August 14, 2020

RE: Special Use Variance / File Number AL-29-028 / Applicant Childers

You have requested my professional assessment as to the suitability of a proposed development project, location: 16810 S. Peyton Hwy, Colorado Springs, CO 80928.

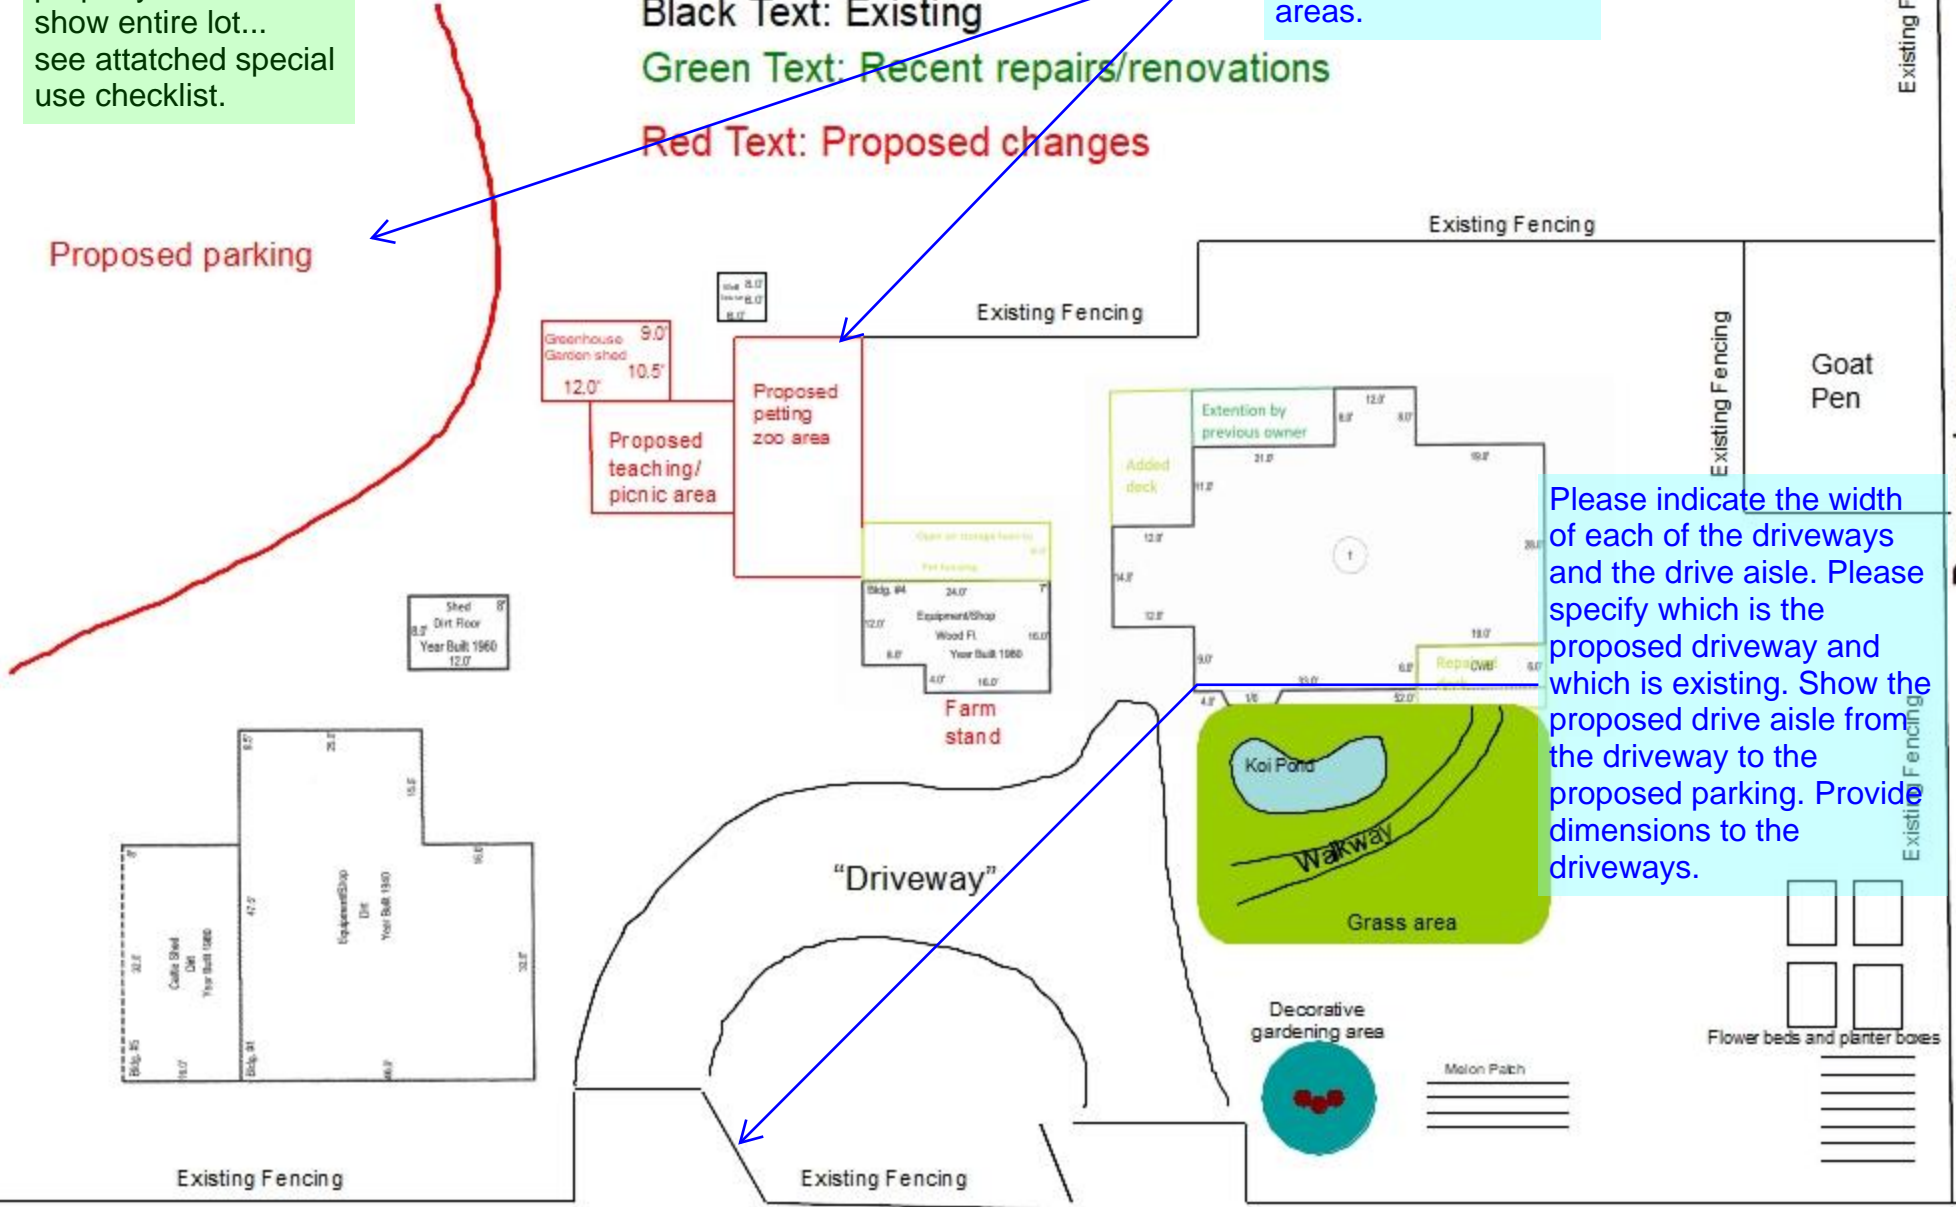
4. **From the unscaled site plan submitted, it is impossible to understand the actual area of disturbance.** The Applicant states that no more than ½ acre will be used for their business. In fact, it will be far more than ½ acre because there are now going to be four (4) ingress/egress points versus the current and typical one (1) point of entry/exit for residential properties (current zoning). This would include one dedicated to parking, ingress and egress for buses and large vehicles (south of the existing barn/workshop building); one (1) for their residence and two (2) for access to the Muddy Little Cowboy Ranch.

10. The circular drive drawn on the site plan does not note the type of drive material required. It should be asphalt however, in the absence of that, the Development Code allows for rock, block pavement, or the equivalent. It is my experience that rock will not last (requiring reapplication on a regular basis) and a dirt drive is completely unacceptable due to drainage issues, and muddy conditions. For safety, a fire truck must be able to enter/exit for emergencies or fire protection with minimally 13'6" height. (See Item 8). See also Development Code, Chapter 6, page 24.
